Transport  
for NSW

TfNSW Reference: SYD21/00314/03  
DPE Reference: SSD-15882721

**RESPONSE TO SUBMISSIONS – DORAN DRIVE PLAZA PRECINCT – 2 MANDALA  
PARADE, CASTLE HILL**

**PROJECT NO.**  
 20417  
**REVIEWED**  
 CHRIS PALMER

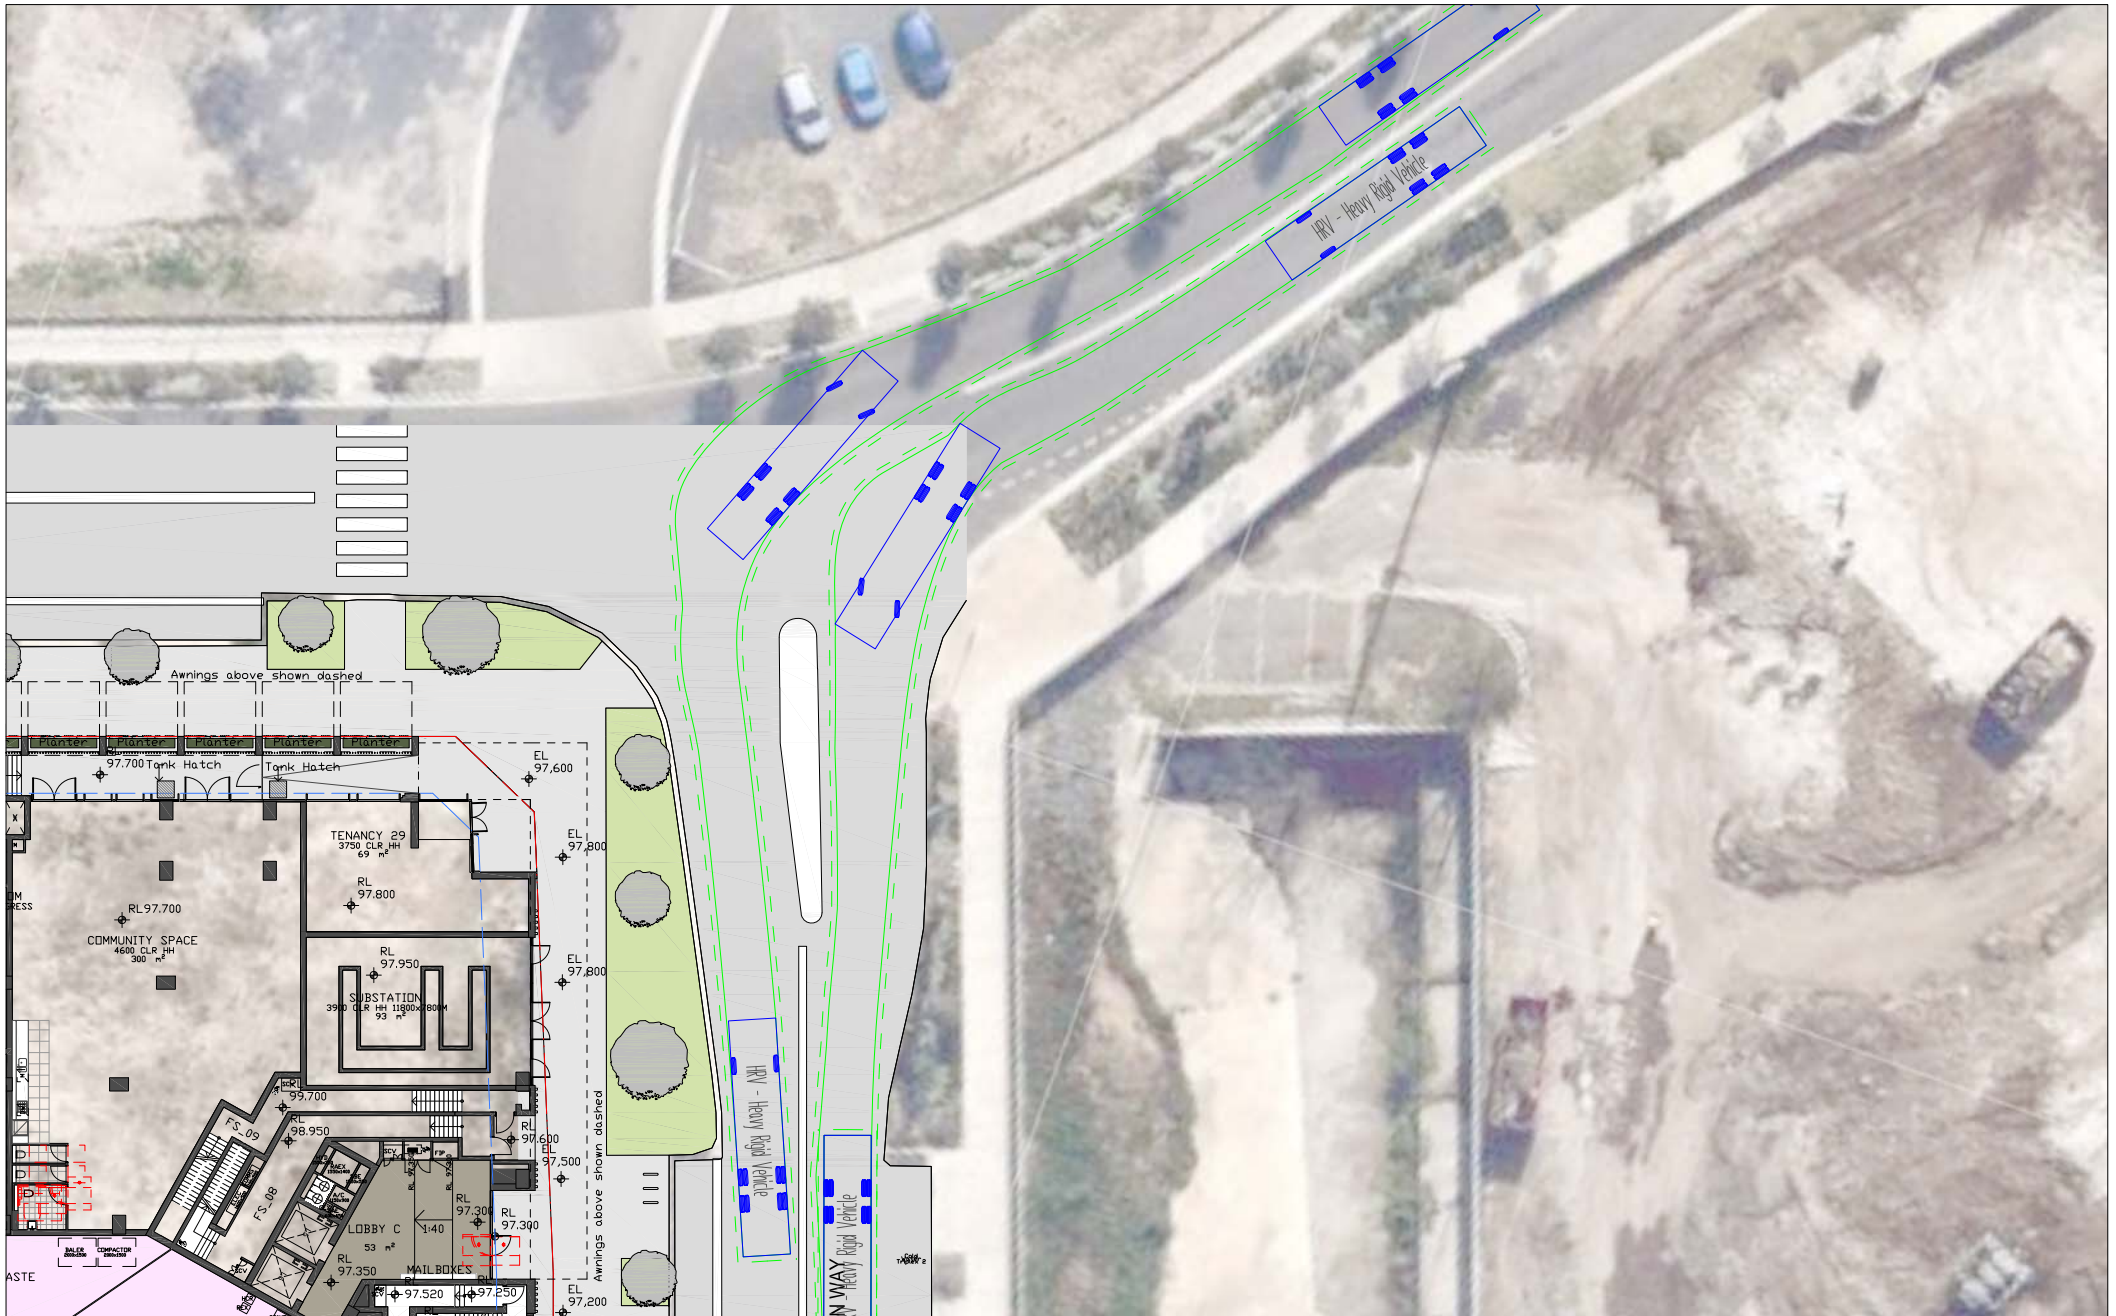
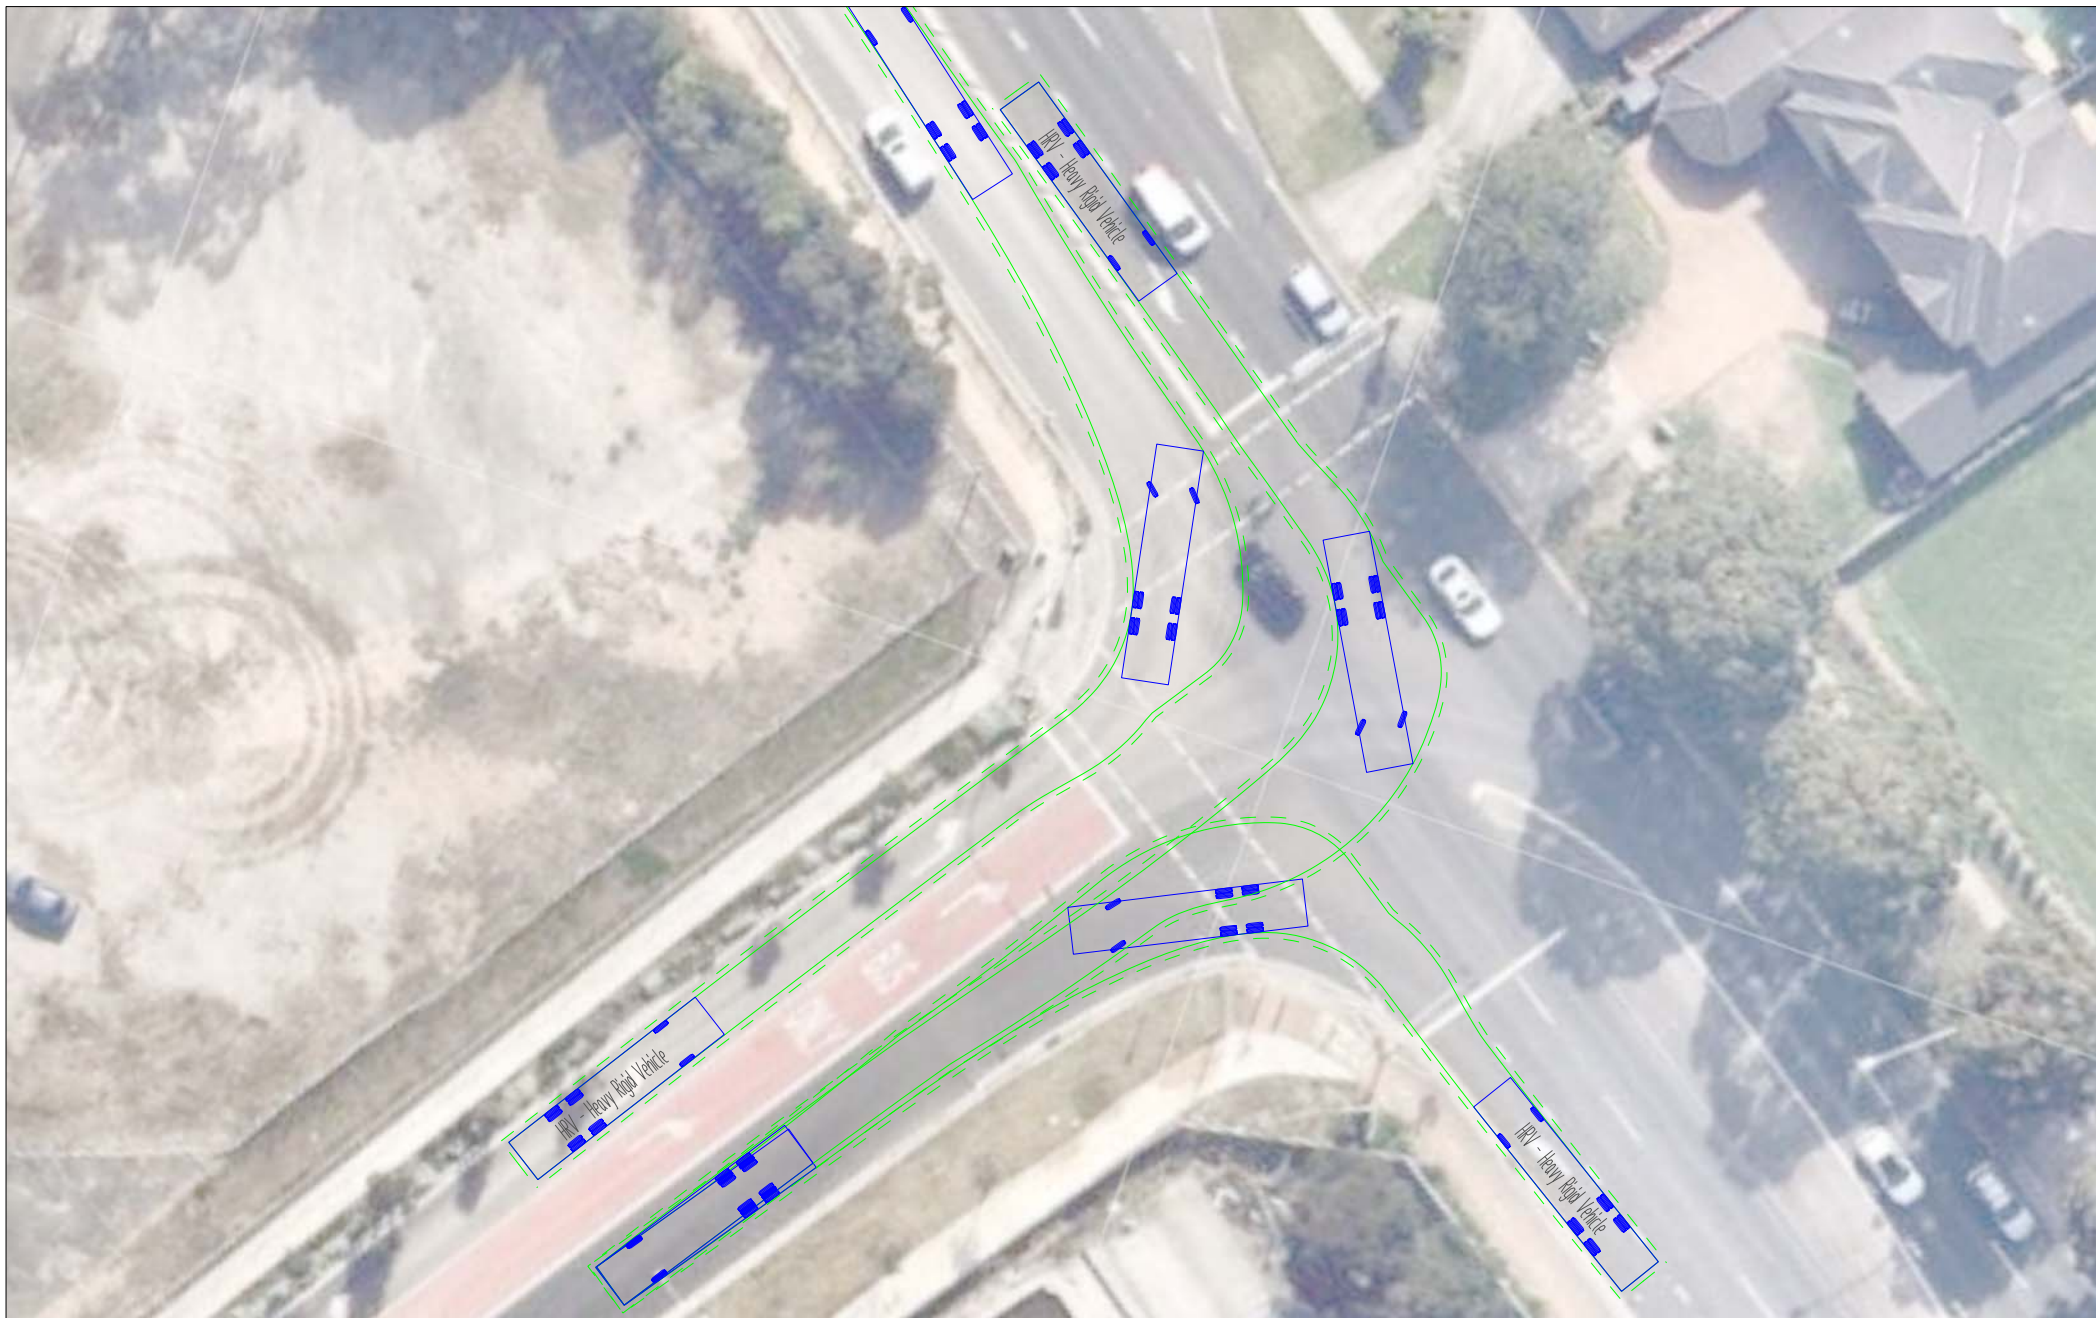
1. The development should be in accordance with the approved Hills Showground Station Precinct Concept SSDA.
2. Consideration must be given the proposed vehicular access to a loading dock at the southern end of the Andalusian Way will not impact upon the pedestrian crossing proposed with the Precinct East development proposal.
3. The proponent is to consider minimising any impacts that proposed landscaping will have on visibility to traffic signals and existing/proposed pedestrian crossings.
4. A Green Travel Plan (GTP) is required to be prepared prior to occupancy.
